Current Zoning: MUDD-O (mixed-use development district, optional)
Proposed Zoning: MUDD-O SPA (mixed-use development district, optional, site plan amendment) with 5-years vested rights

The petition proposes a site plan amendment to approved rezoning petition 2021-092.

Atrium Health, Inc.

Exhibit A – General Sign Locations

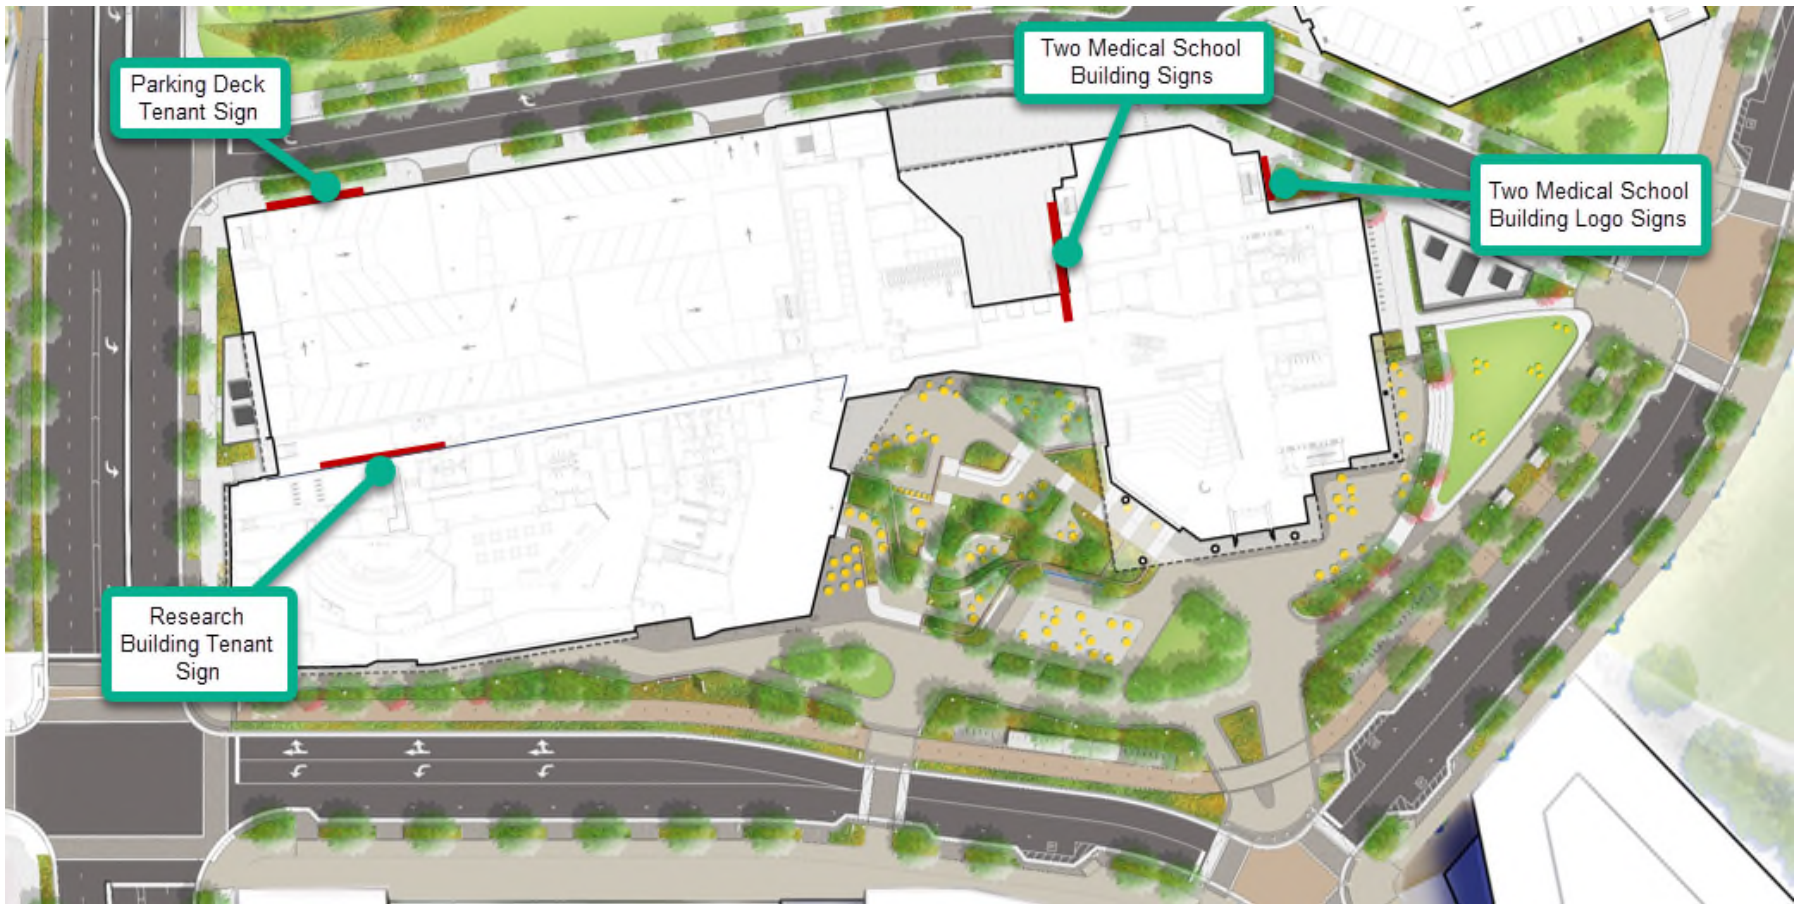
2. ~~Clarify whether the signs proposed in the optional provisions meet the definition of skyline signs or wall signs. Modify as needed.~~ **Addressed**
-

Conceptual Building Section

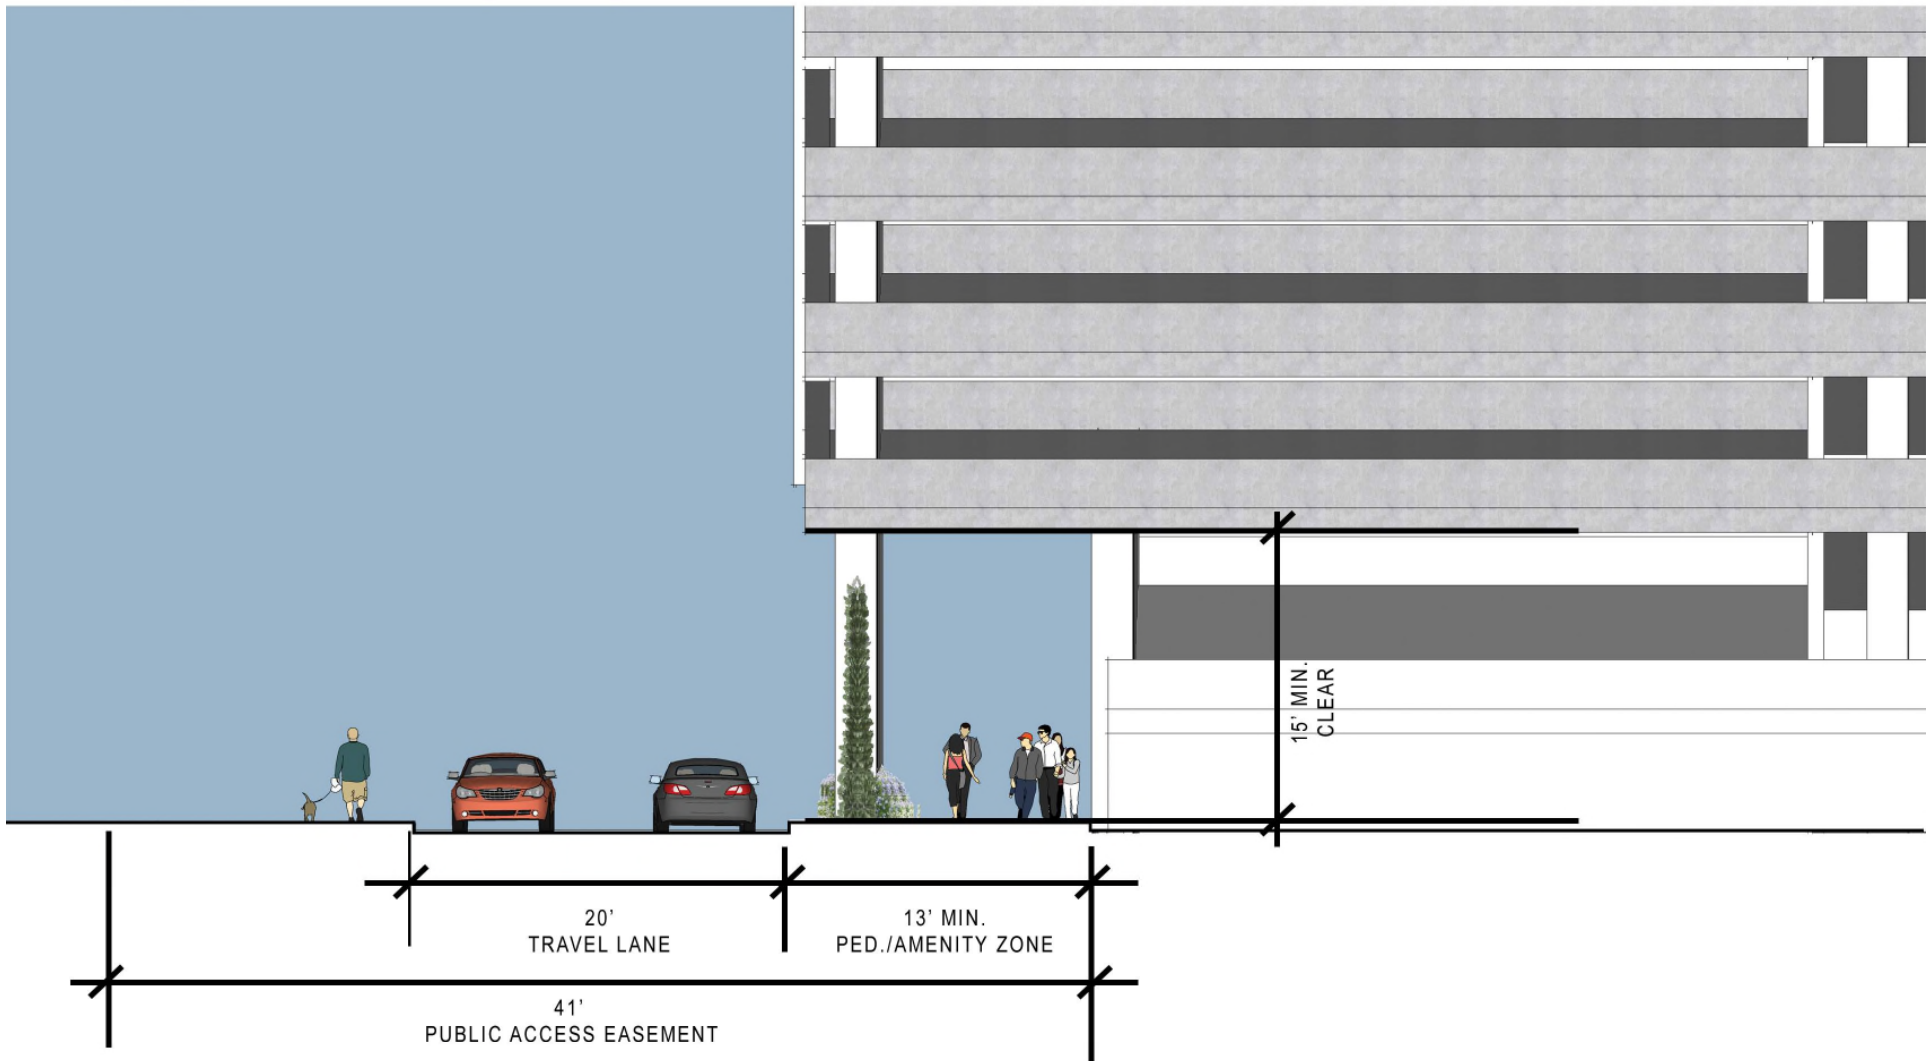
1. ~~Remove item (c) from Section 3. regarding modifications to the setback. Exemptions from required street trees are not an allowed.~~ **Addressed**
